NJA Ref: 21/232

16 June 2021

LPA Ref: FG/90/21/HH
Proposal: Erection of addition of second floor, part single, part two storey extension and wrap around terrace
Site: 1 Sea Drive, Ferring, BN12 5HD

Project: Extension & Refurbishment	
for Chris Levett	
at 1 Sea Drive Ferring Worthing BN12 5HD	
Contact: Michael Austin R/BA E-mail: project@austinglebbon.co.uk Web: www.austinglebbon.co.uk Phone: 07958427610	
Dwg Ref: 2048 [PL] 06	Rev: - Date: May 2021

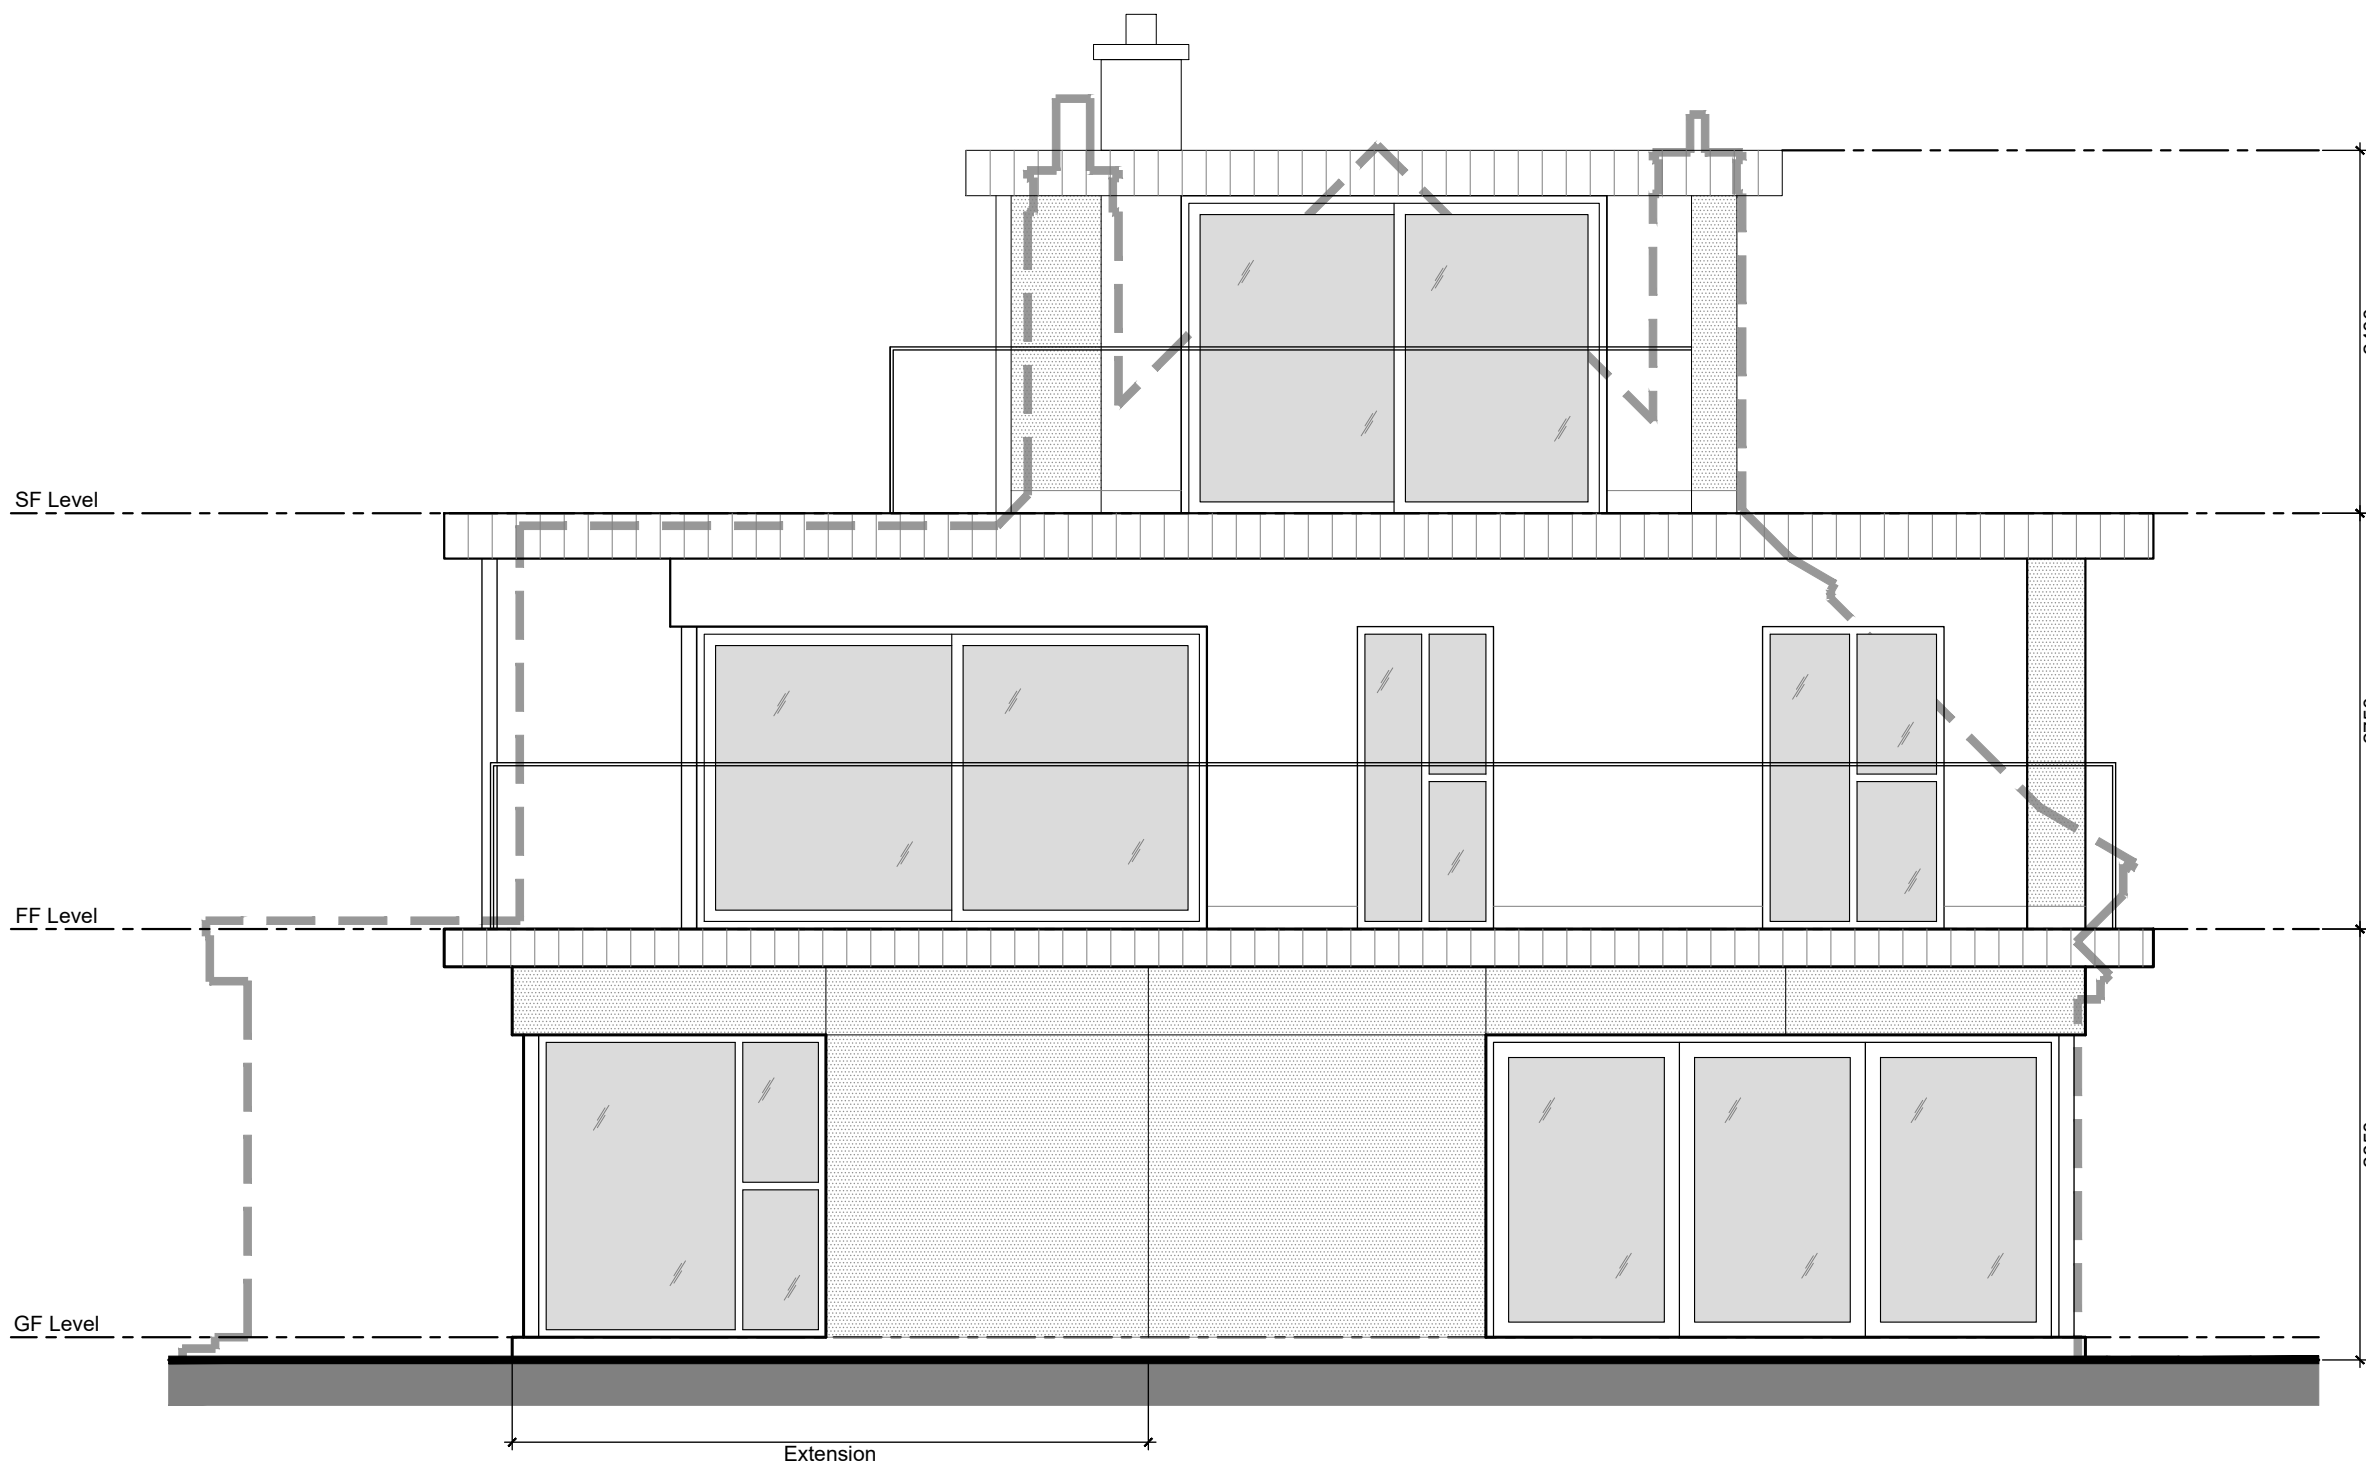
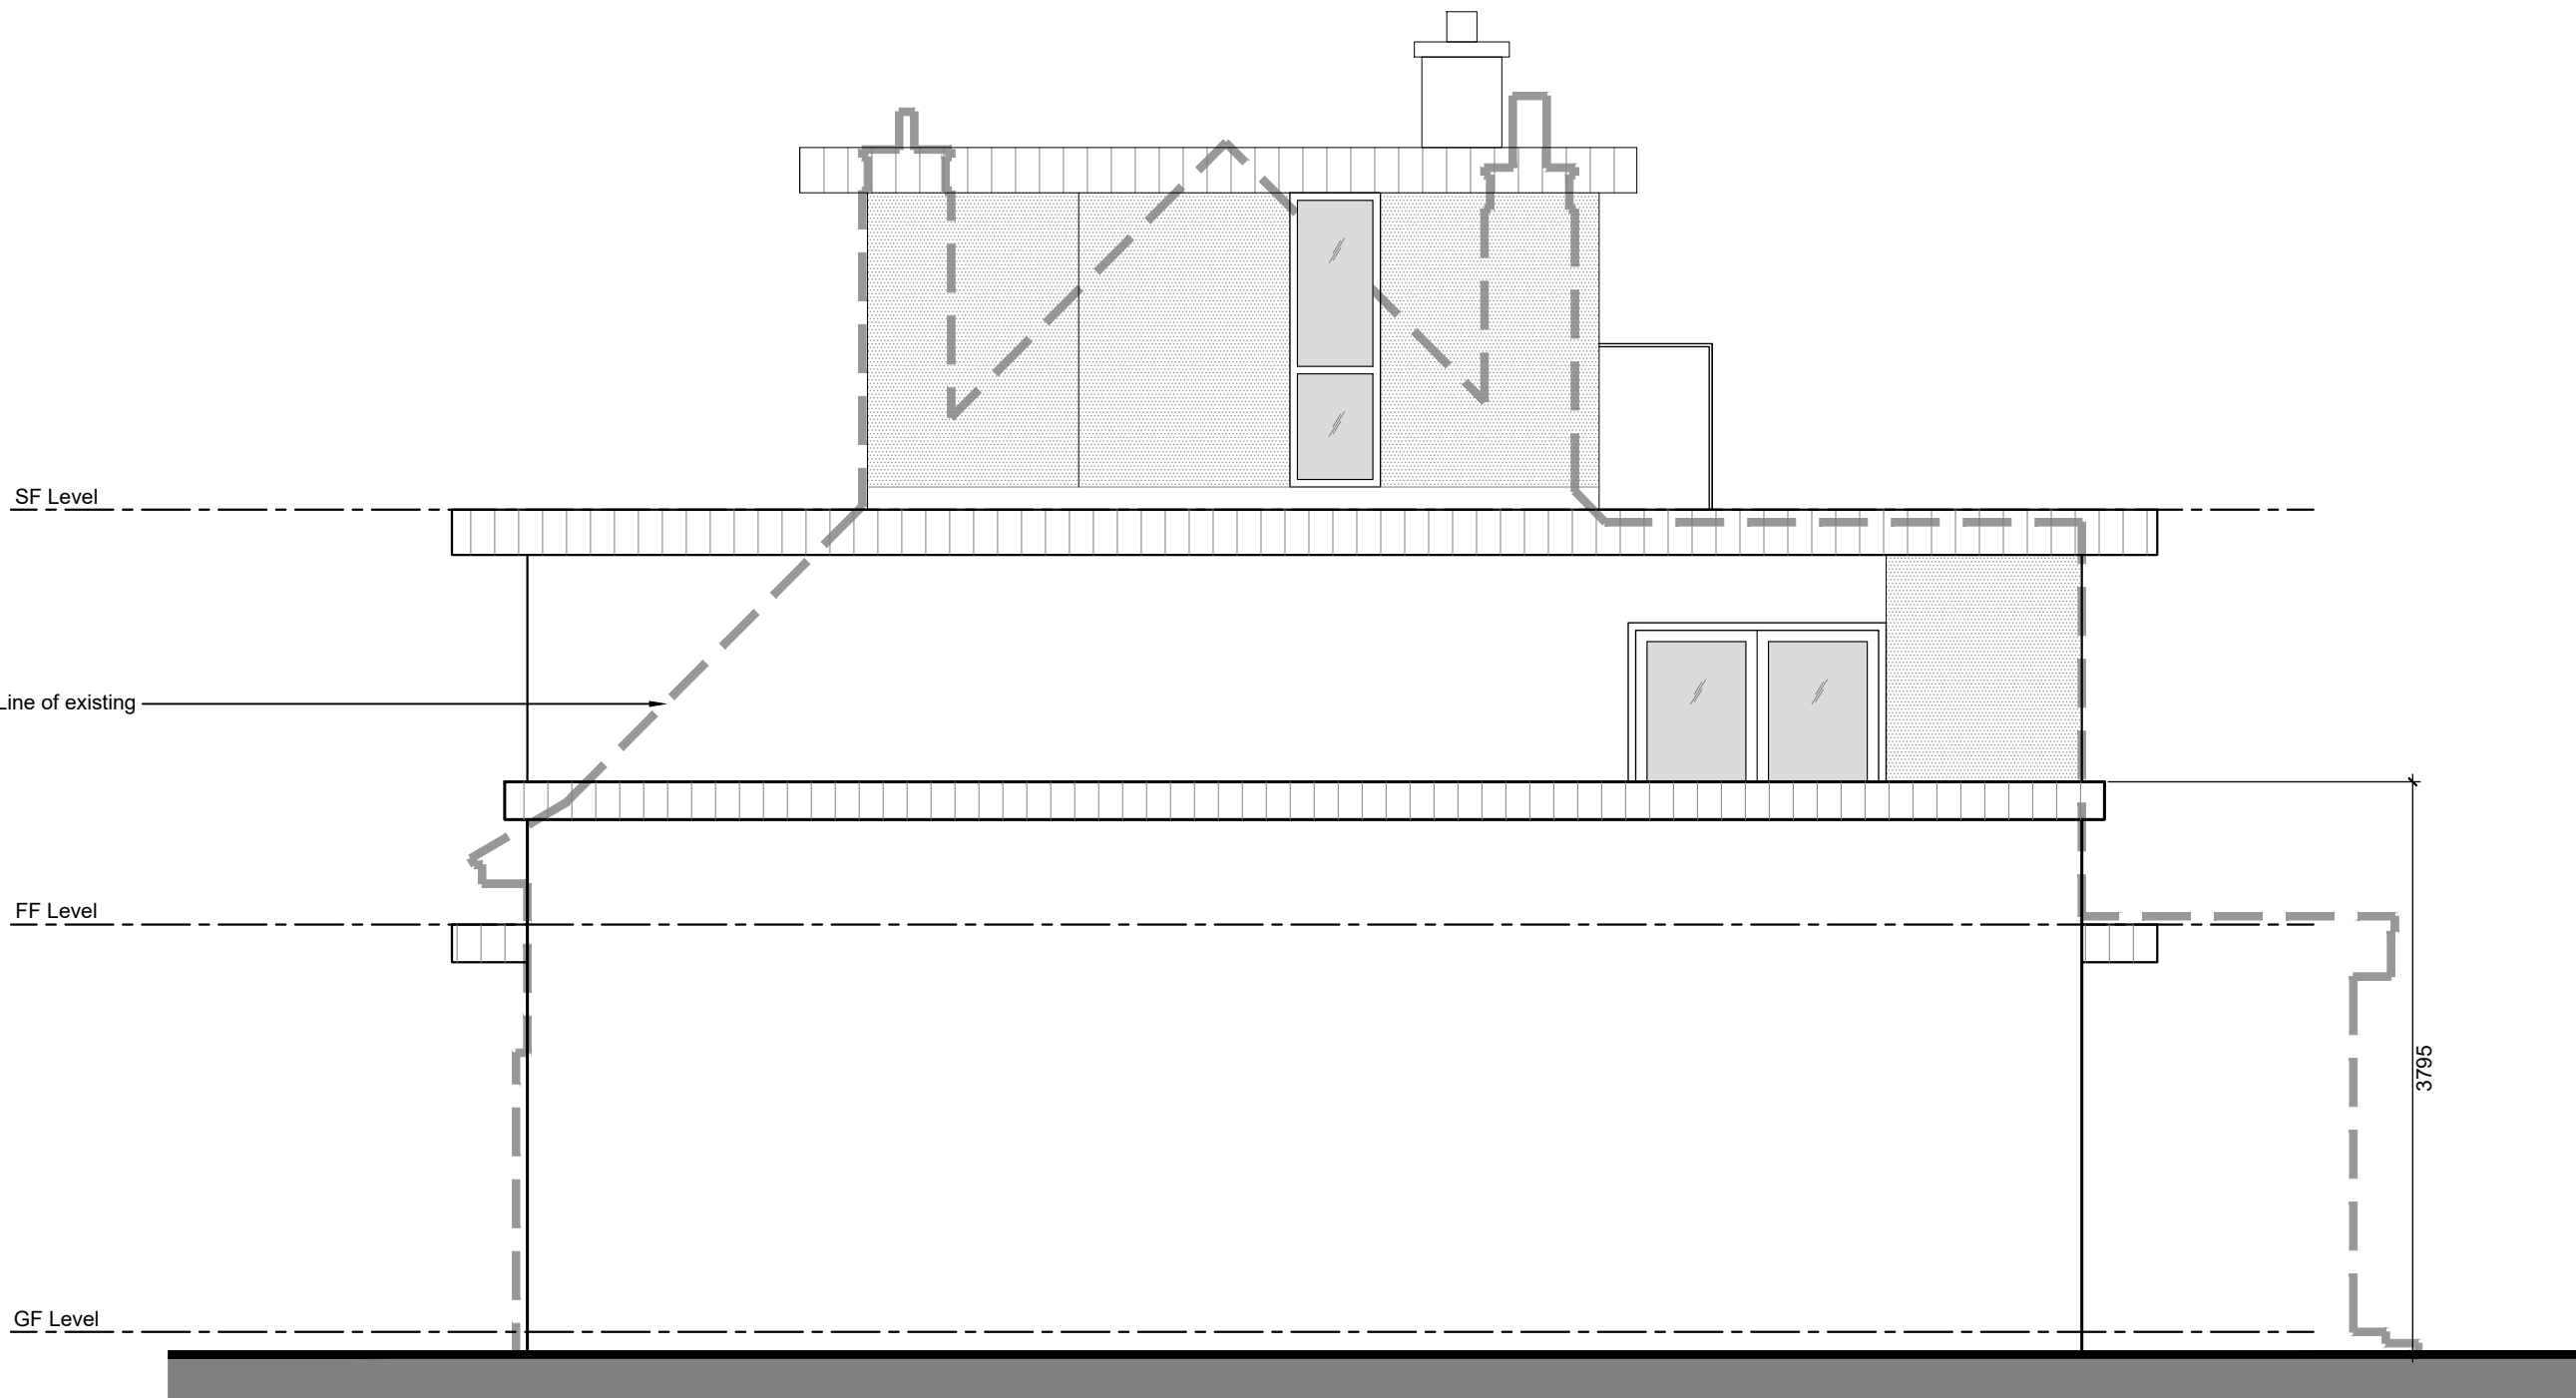
The proposed terrace above the existing garage has the potential to cause unacceptable levels of noise and disturbance given its size and proximity to the common boundary. Furthermore, the wall surrounding the terrace is low which will allow for harmful overlooking of private amenity space at number 3, including the front first floor balcony which itself was specifically designed to respect the privacy of the occupiers of number 1. The front garden at number 3 is a well-used amenity space due to its southerly aspect and as such the owners have created a patio area in this location. It is also a private and enclosed space and given its use this area should be afforded the same weight as the rear garden of the property in considering impact upon privacy.

In addition, the proposed first floor patio doors to the terrace and second floor window to the western elevation of the dwelling will allow unacceptable direct views into the first floor balcony (less than 1 ft away) and front and rear garden areas at number 3. Currently there is only one first floor dormer window to the west elevation of number 1 which is a later addition, set into the roof slope away from the boundary and which is fitted with obscure glass (as required by condition). Therefore, the existing situation to this elevation would be substantially altered through the creation of a large terrace and new windows that would be detrimental to the residential amenity of number 3 by reason of loss of privacy caused by overlooking and the potential for harmful noise and disturbance.

The proposal includes substantial changes to the design of number 1 including its roof form which will be altered from a pitched to a modern flat roof design. This will result in a dramatic alteration to the dwelling's present chalet style appearance, changing it to a three storey dwelling. As a result, the dwelling will appear very overbearing to number 3 and given the addition of a second floor and substantial overall increase in scale and bulk, it will unacceptably block light to the private amenity spaces at number 3.

Due to the present chalet style design of number 1, the only windows to the rear elevation of the dwelling at first floor level are three small windows set into the roof slope. However, the proposal in contrast includes the insertion of a large number of ground, first and second floor windows and doors to all elevations. The number, siting and full length design of the windows and doors would appear excessive and would unacceptably overlook the private garden areas at number 3 and the rear garden of the dwelling to the north, 108 Sea Lane. The combined appearance of these windows would create an oppressive feel to neighbours and the level of overlooking would be detrimental to privacy and wholly unacceptable.
